City of Albuquerque
Planning Department
Development Services Division
P.O. Box 1293
Albuquerque, New Mexico 87103

OFFICIAL NOTIFICATION OF DECISION

FILE: **Project # 1002332**

02EPC-01690 Zone Map Amendment
02EPC-01692 EPC Sector Development Plan
02EPC-01694 EPC Site Development Plan-

SITE PLAN

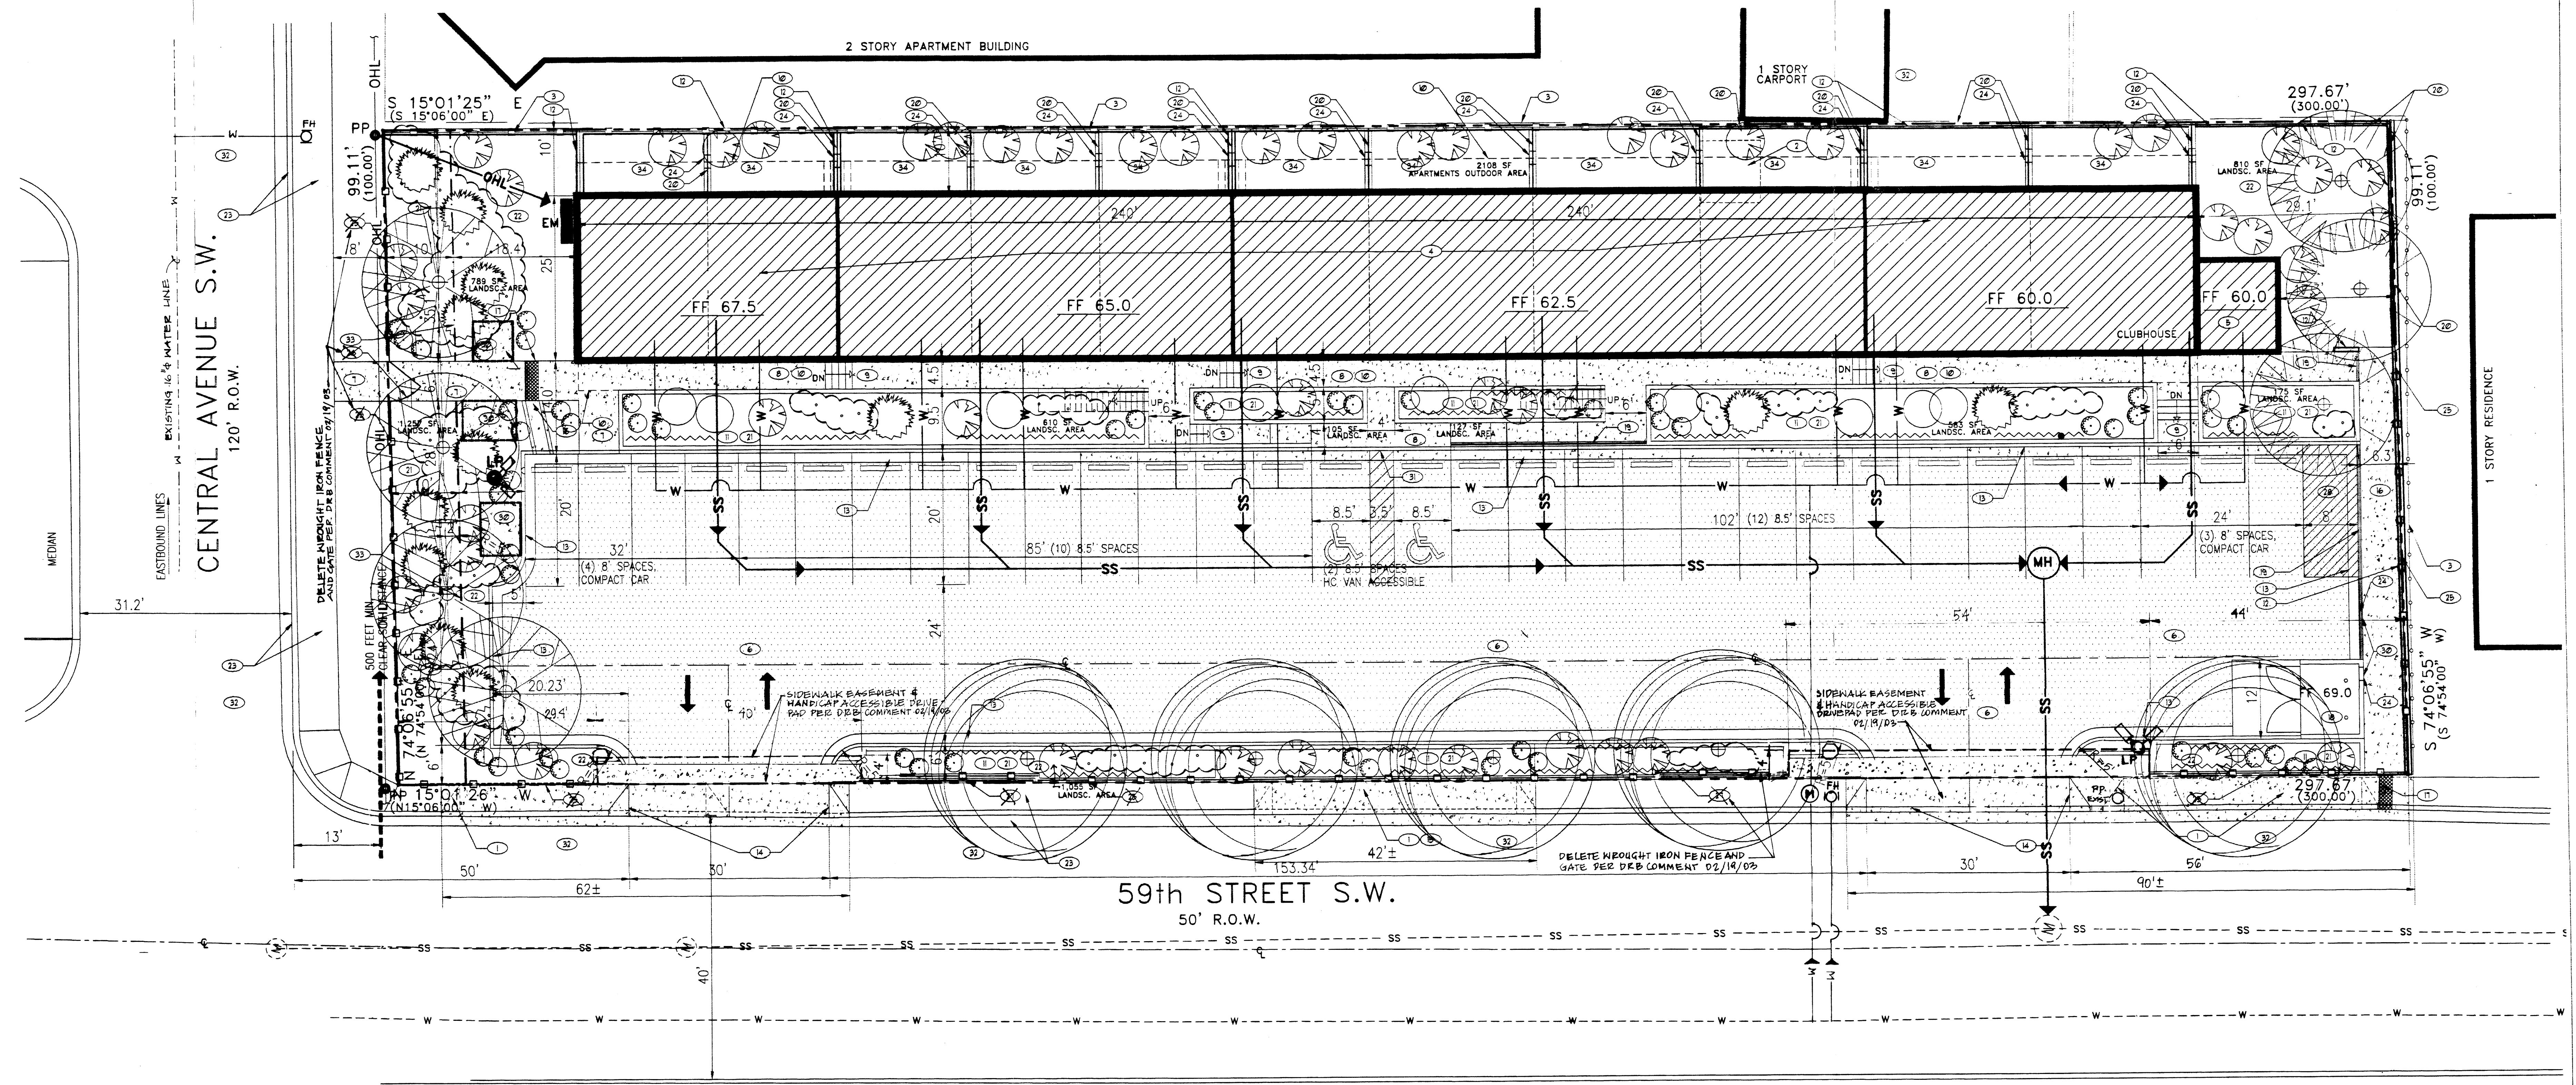
- b. Site Plan shall comply and be designed per DPM Standards.
 - c. Driveways to be 25' minimum width. Curb returns with 25' radius recommended but not required.

- d. Driveways to be located a minimum of 50' from Central.
 - e. Provide 5' keyed area at south end of parking lot.
 - f. No passenger car parking adjacent to refuse container.

- g. Sidewalk adjacent to parking shall be 6' wide.
 - h. Provide for clear site distance at the intersection of Central and 59th St. per AASHTO.

3. A new 6 ft. high fence is to be built at the south end of the side that incorporates material and design characteristics similar to those intended for the building balcony railing.

4. The developer shall install street trees adjacent to Central Avenue and 59th Street that will produce a 25-foot canopy at maturity.
 5. The developer shall install additional Cherry Plum and/or Crabapple trees in the southeast corner of the site to provide additional buffering for the adjacent single-family residences.

6. The applicant shall identify outdoor areas for each apartment on the site plan.
 7. The dumpster shall be relocated to an area away from Central Avenue.
